Please ask for: Nicola Moore
Email: nicola.moore@arun.gov.uk
Telephone: Ext 37944
Our Ref: WA/83/21/L
Your Ref:
Date: 8th October 2021

Listed Building Consent for Alterations, Extension or Demolition of a Listed Building

Development: Listed building consent to replace existing french doors with like for like and with heritage slim double glazing
Location: 8 Walberton Park Walberton Arundel BN18 0PJ

Proposed: Cream Sashwood
Floor: 1st - 2nd Floor Cream, Ceiling
3. Sash Terrace / Verandah
Chapman, Darter, Darter
Scale: 1:1
Chapman, Darter, Darter

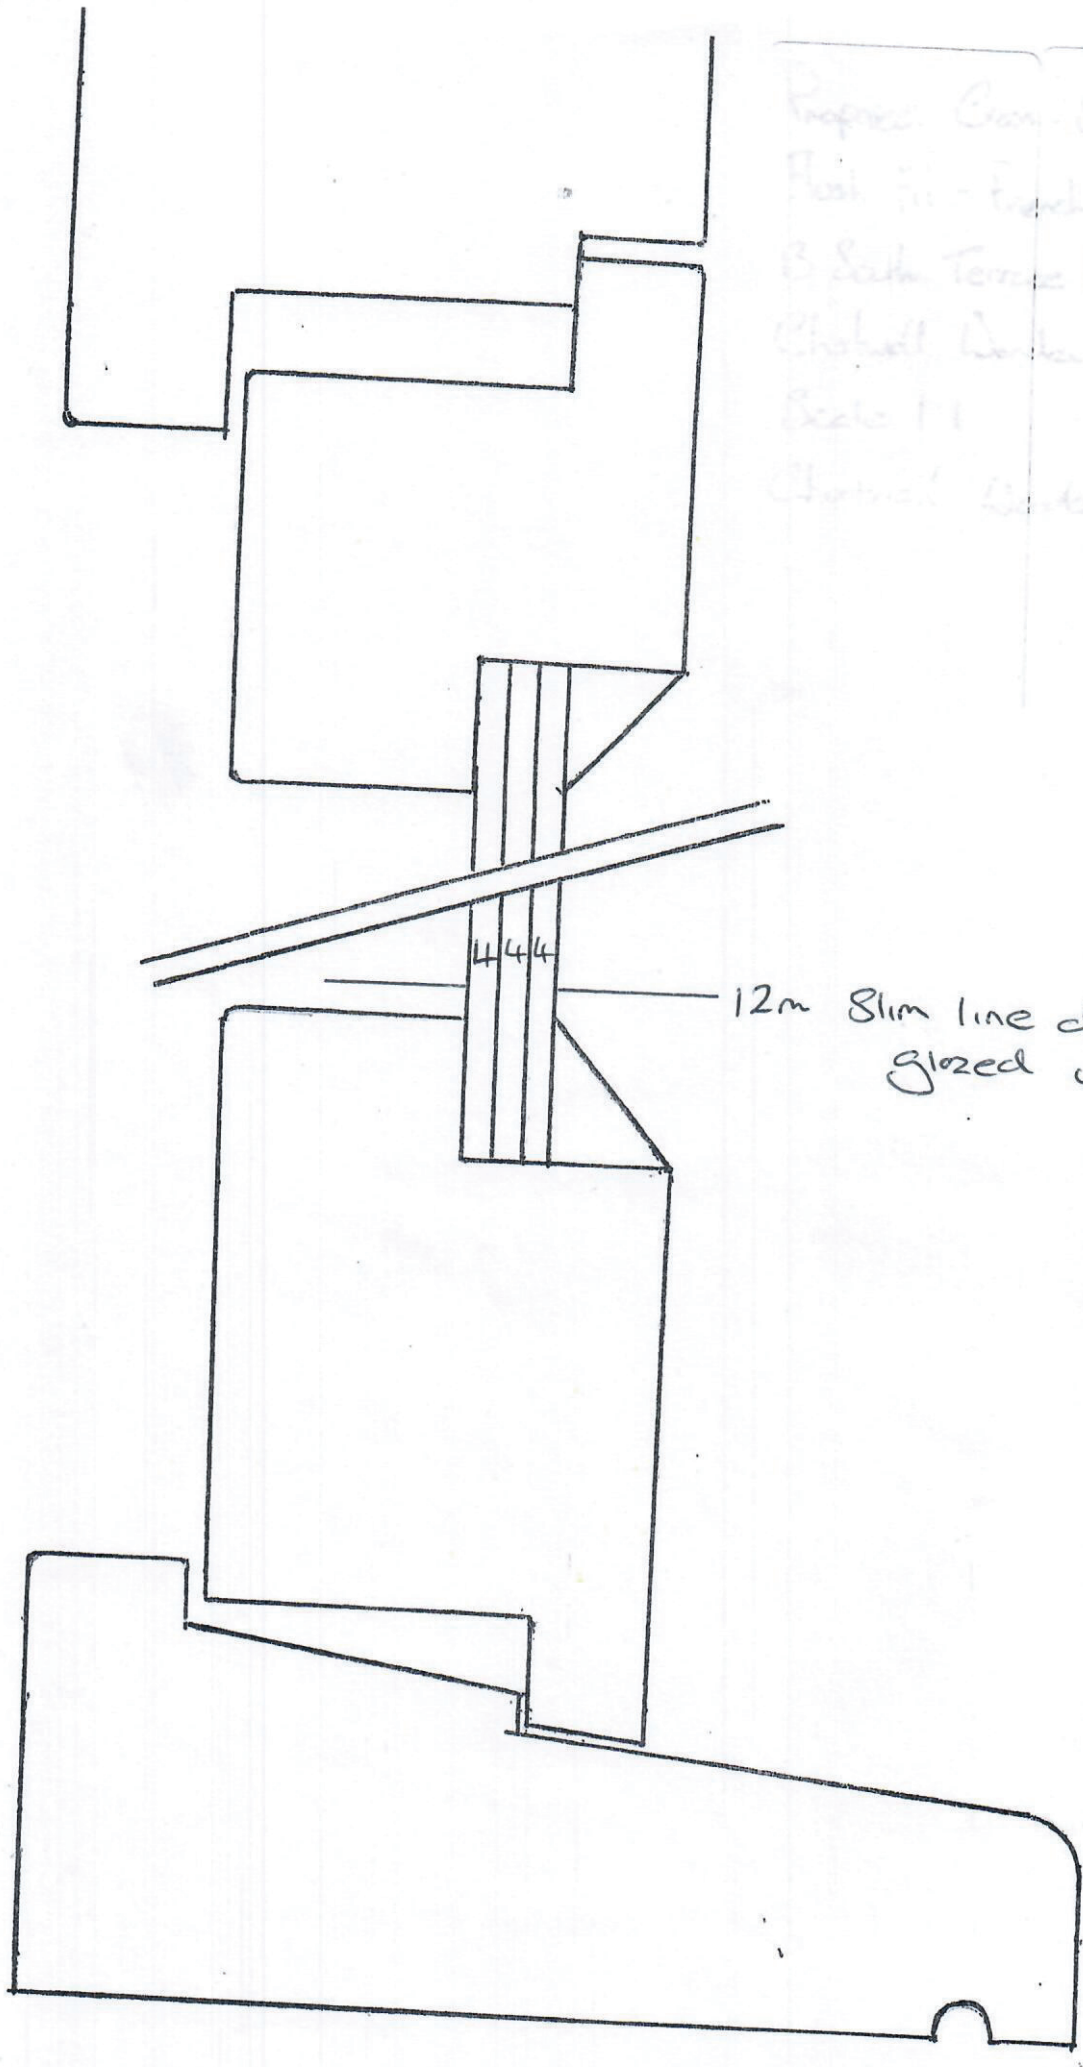
For clarity, please confirm the colour of the proposed replacement door.

8 Walberton Park, The Street, Walberton, Arundel, BN18 0PJ

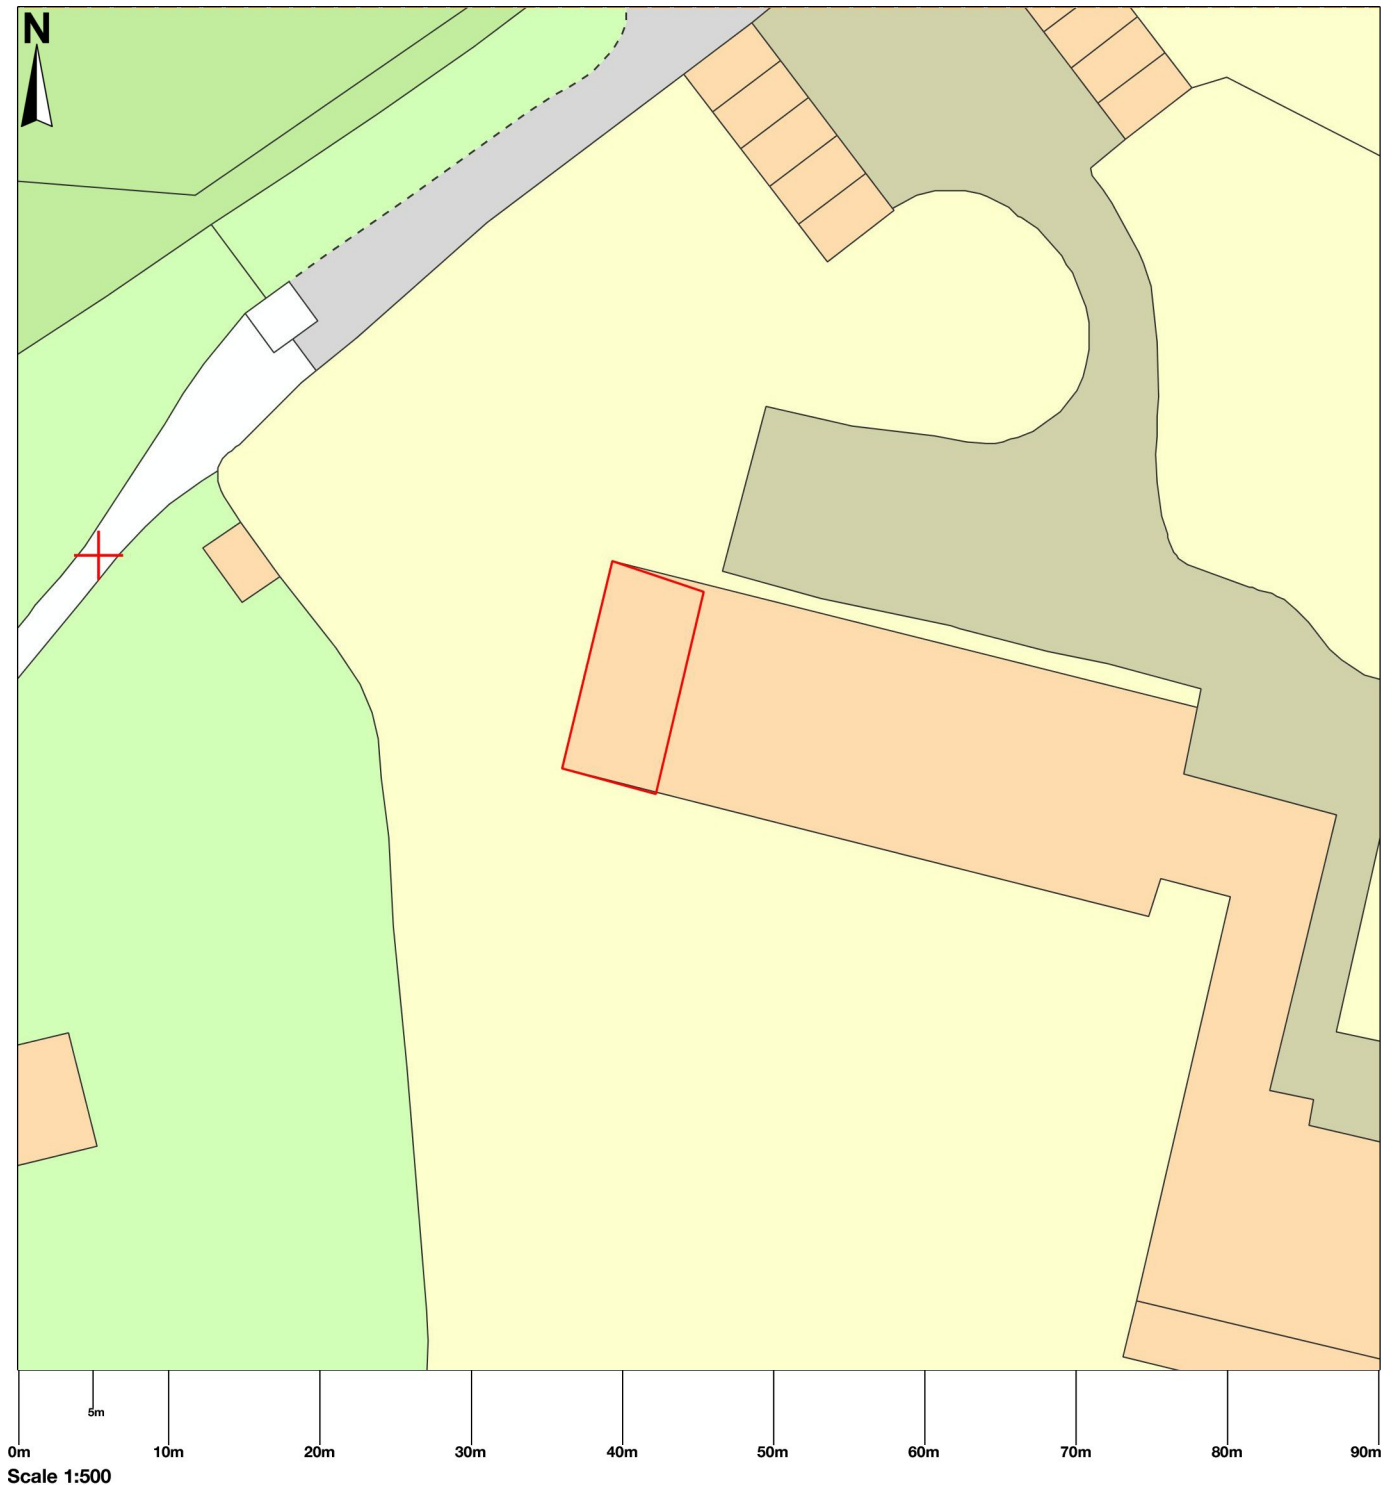
The Block Plan should clearly indicate where on the property the door to be replaced is located. This can be a bold line or an 'X'. Please amend accordingly and re submit. Further details of what must be included on the plan can be found in the Validation Requirements List.
